Planning Application: **OUTLINE** planning application for 10 dwellings with access from Hoe Lane – resubmission from Y/40/17/OUT.

Reference: Y/20/18/OUT

Location: Bonhams, Hoe Lane, Flansham

Consultant Arboriculturist

Land at Bonhams

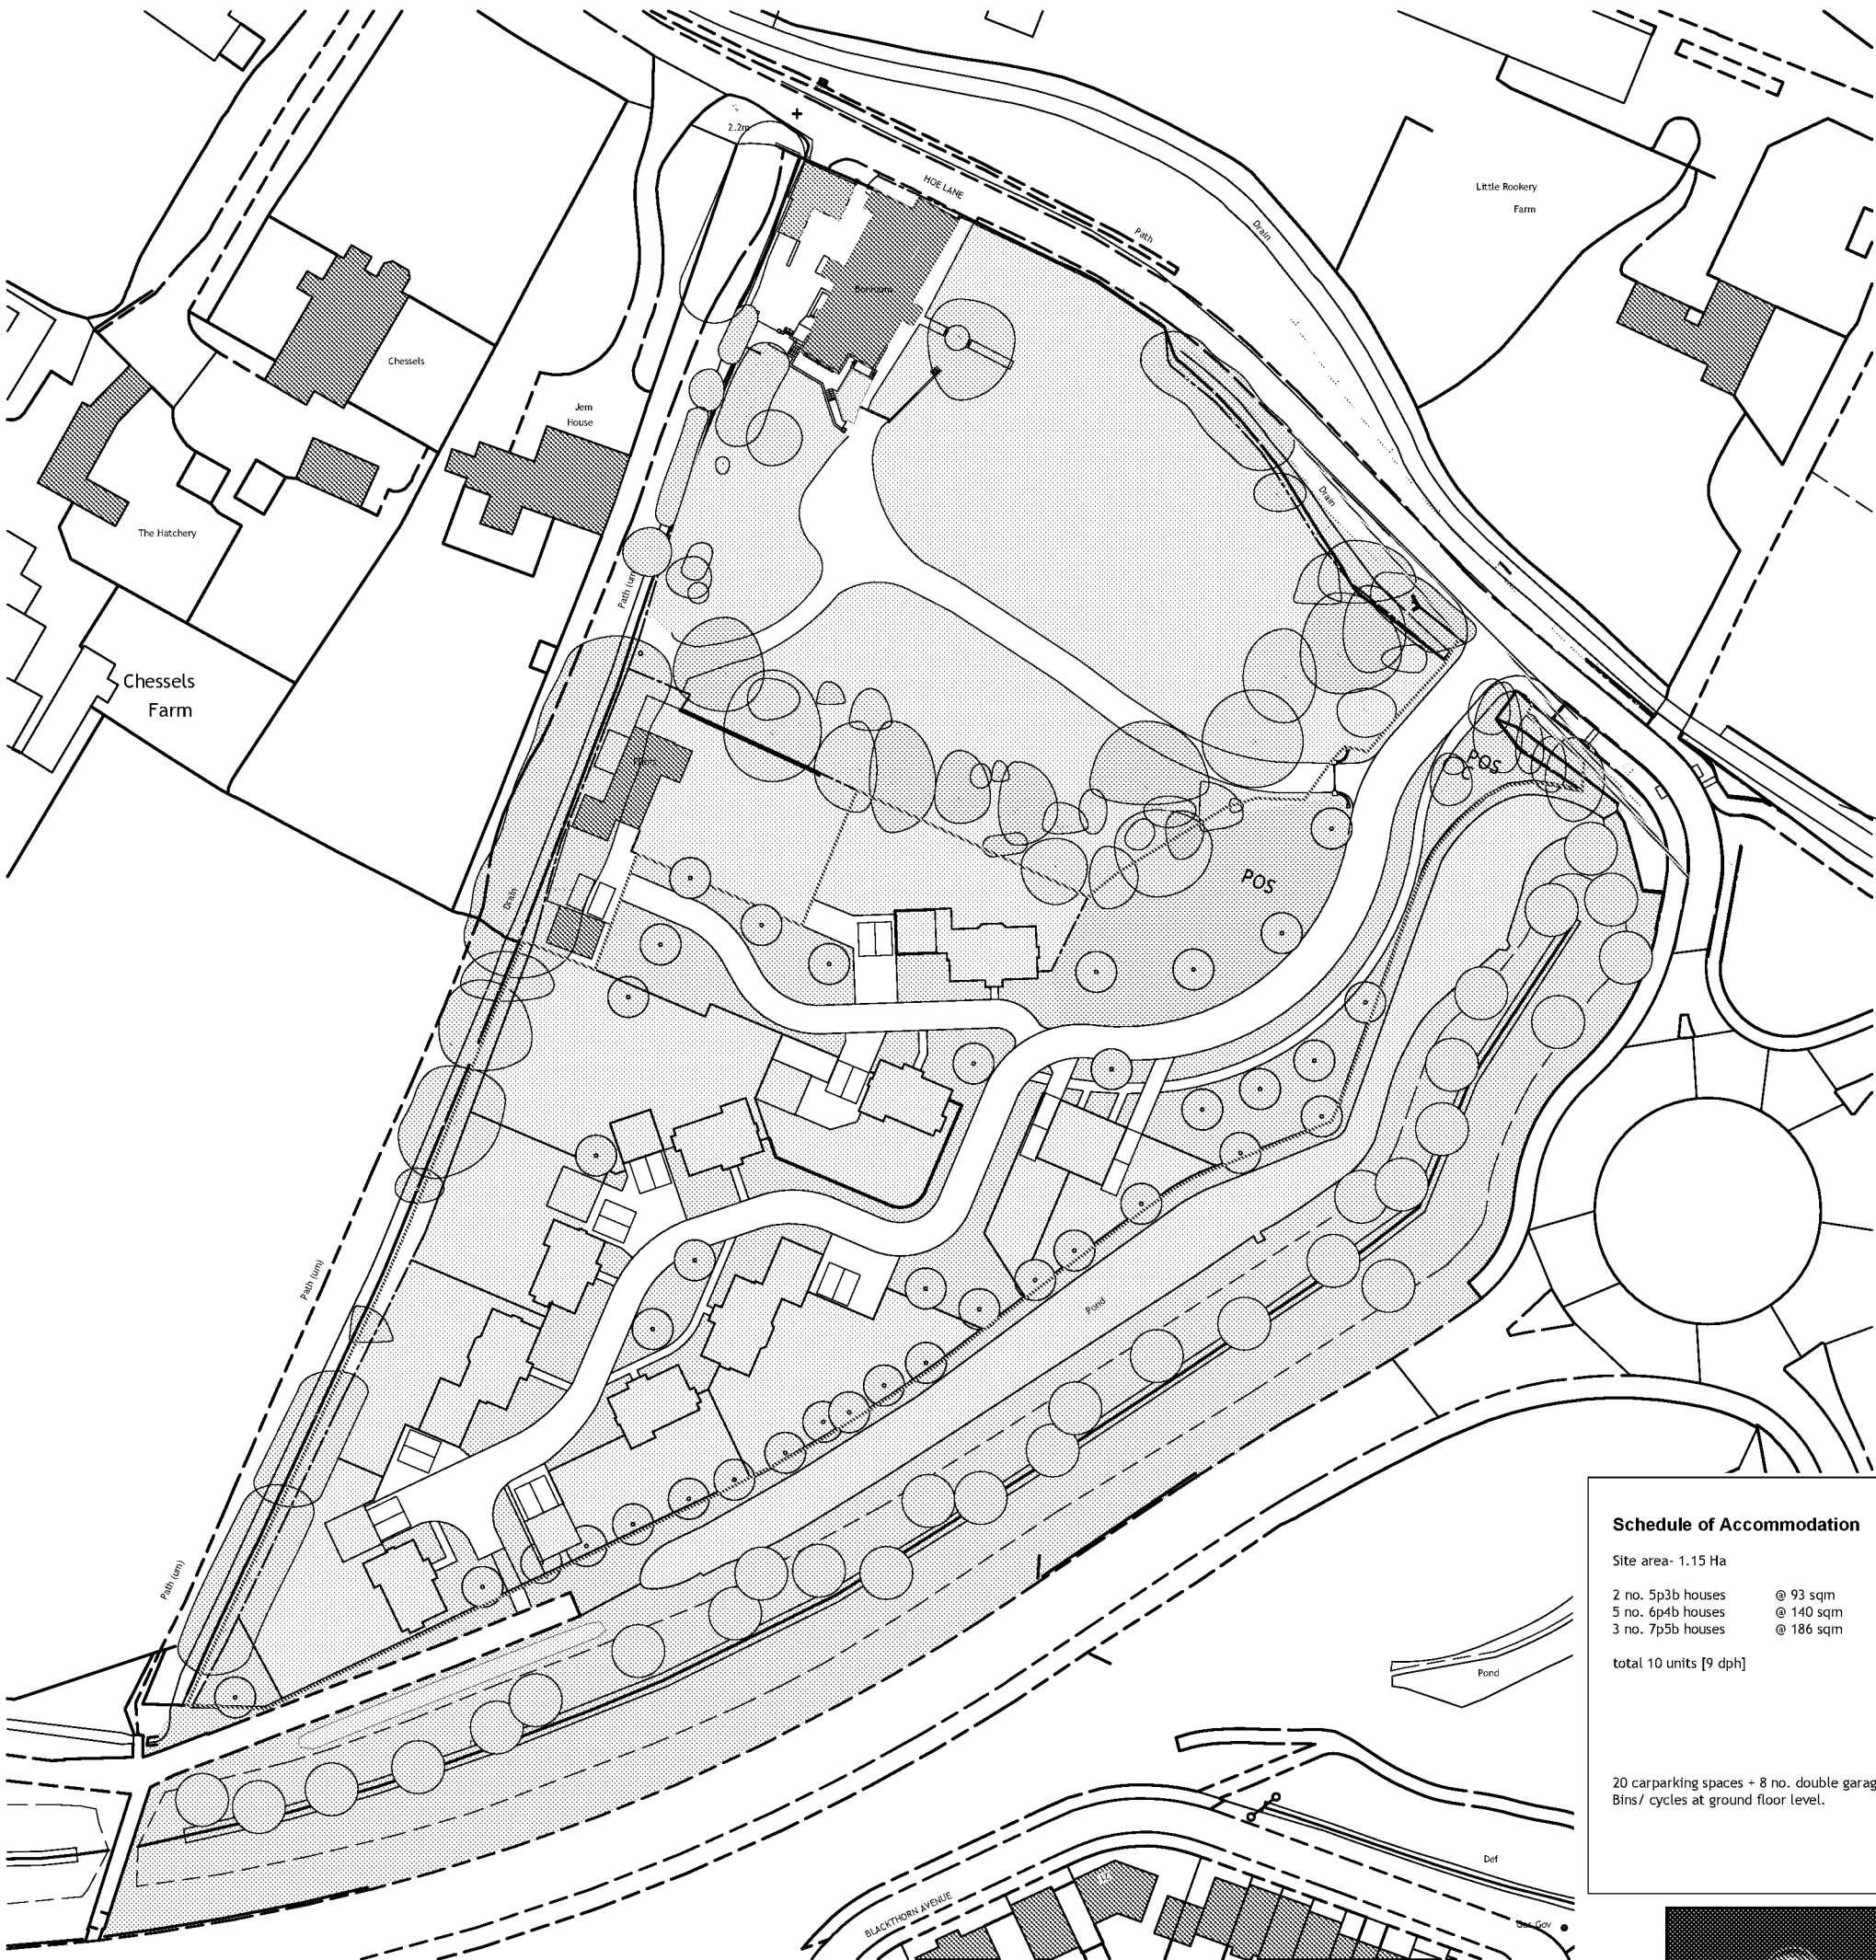
- The current layout shows 10 dwellings and in general these are set well back from any trees except for Grp 9 Field Maples in the bottom southeast corner where a garage block is placed very close to them and within their RPA. These are healthy trees which are highly prominent and important features in the landscape and should as such be fully respected.

- IF this site is developed as outlined on the draft plans then I would have only one real concern on tree grounds – the intrusion into the RPA of Grp 9 Field Maples and pressure to prune or fell which might ensue.

- I raise an **OBJECTION** to this scheme on the grounds that it threatens Grp 9 Field Maples – although if the scheme could be amended to accommodate the full RPA of these trees then I would be prepared to withdraw my objection.
- I withdraw my Objection to this Outline scheme as the plan they have now submitted at a larger scale clearly shows the RPA of the Field Maples (Grp 9) is clear of the Garage block and it should be possible to fence it off and afford full protection to same.
- However, I would reiterate that - When this application comes back in for FULL planning it will need to be accompanied by :-
